**Item No.**                      **Report of the Interim Director of Planning, Regeneration & Public Realm**

**Address**                      60 LONG LANE ICKENHAM MIDDLESEX

**Development:**              Demolition of existing dwelling and erection of two storey detached building with habitable roof space to provide 8 x 2-bed flats and 1 studio flat with associated amenity space and parking.

**LBH Ref Nos:**                **70282/APP/2022/1143**

GROUND FLOOR

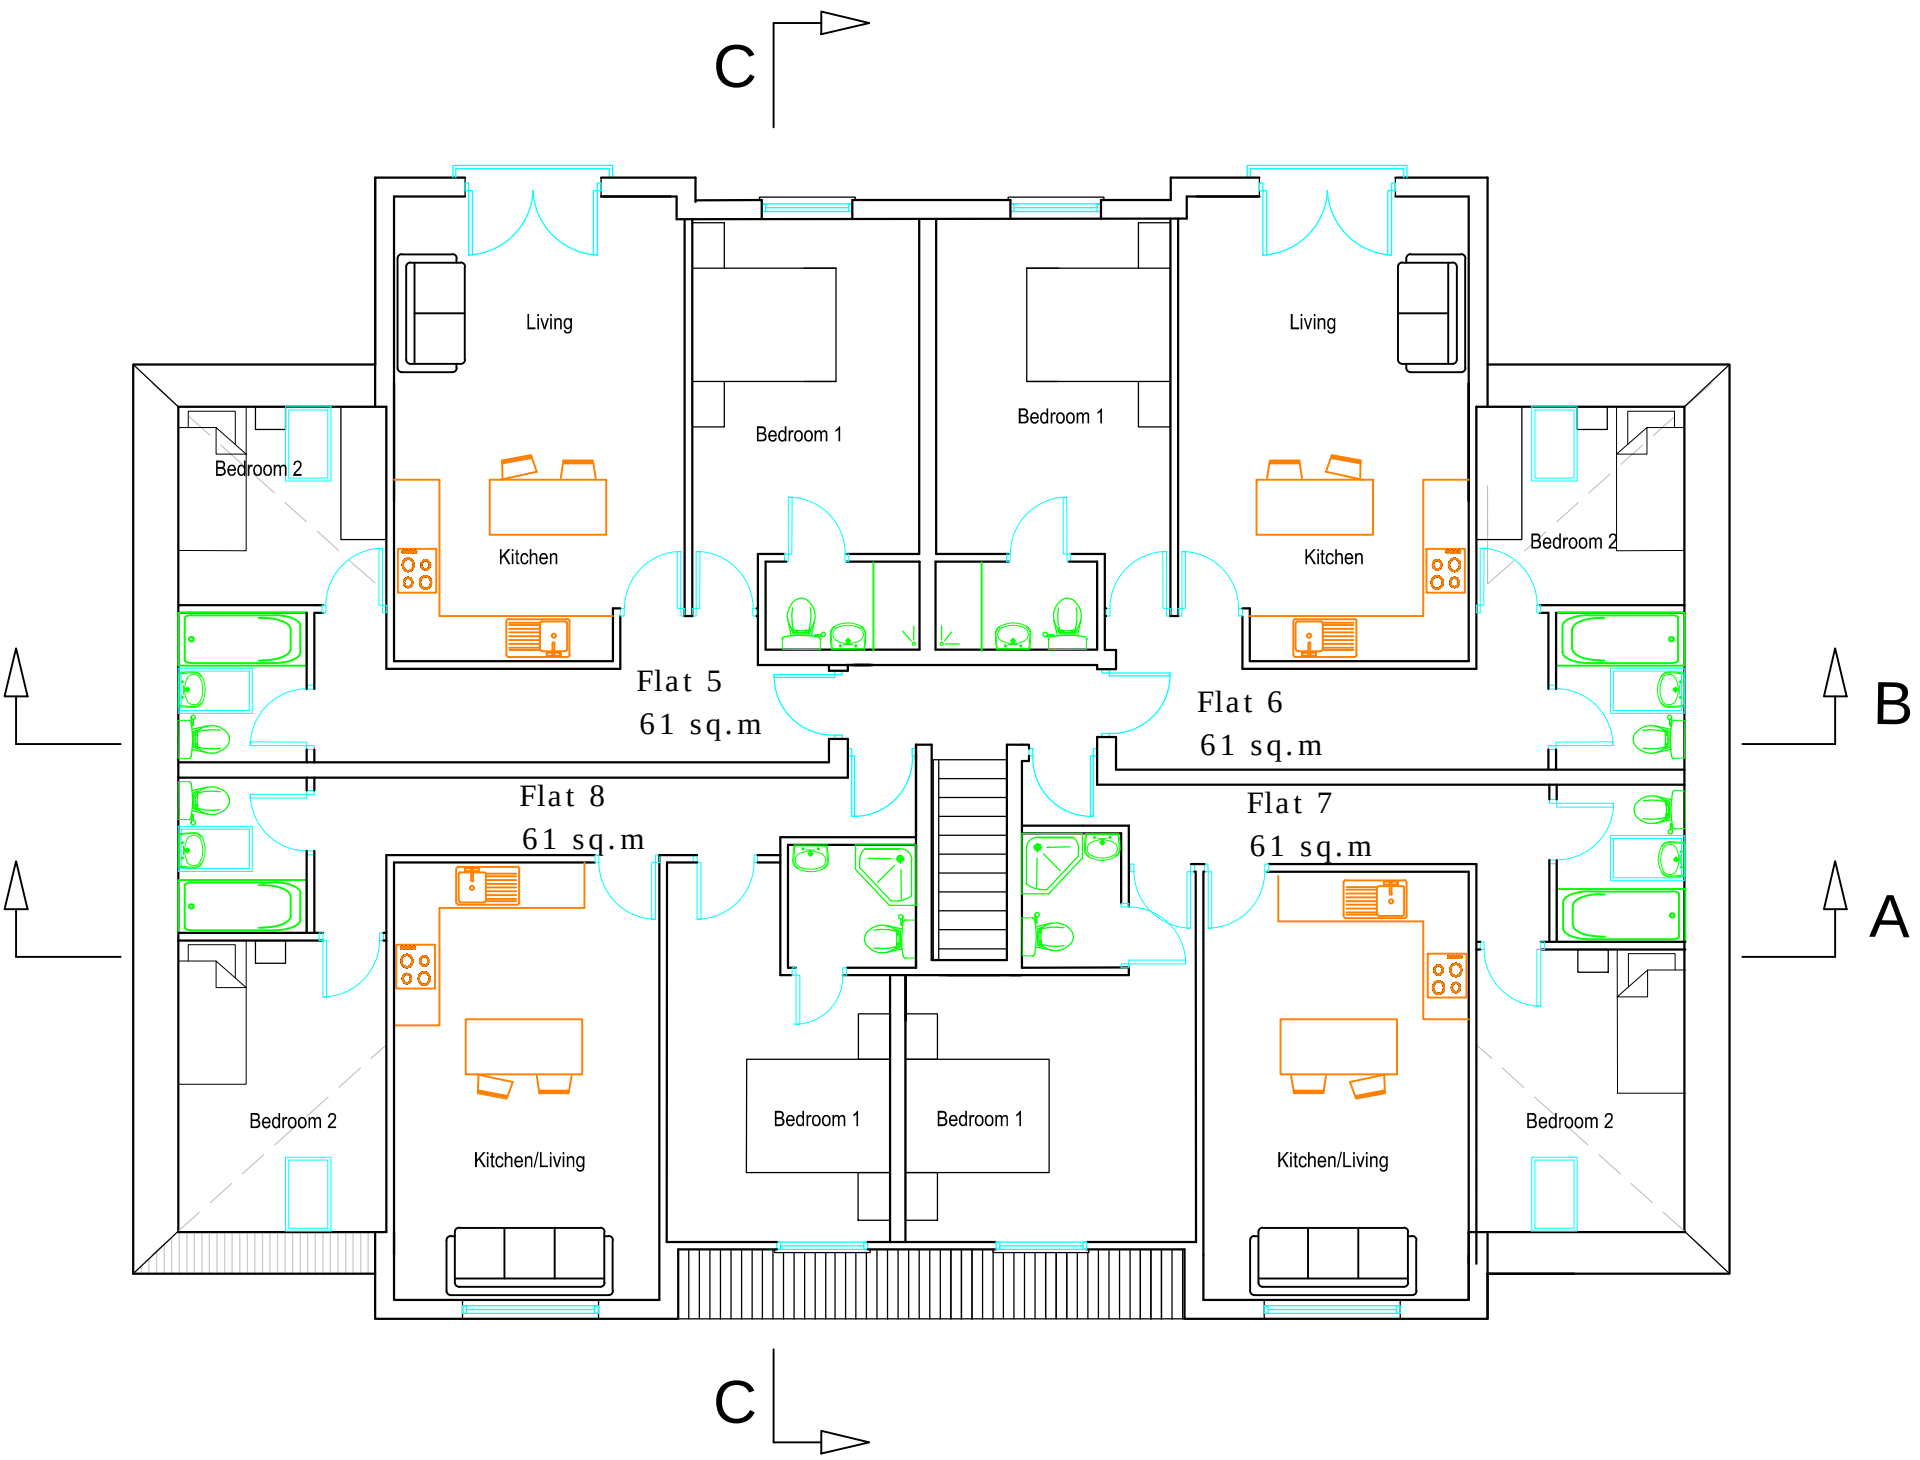
The proposed development, by virtue of the substandard internal floor area of the single bedrooms, would result in substandard forms of residential accommodation to the detriment of future occupants of Flats 1, 2, 5 and 6. The proposal would therefore result in substandard forms of residential accommodation to the detriment of the amenity of future occupants of the proposed development, contrary to Policy DMHB 16 of the Hillingdon Local Plan: Part Two - Development Management Policies (2020), Policy D6 of the London Plan (2021) and the National Planning Policy Framework (2021).
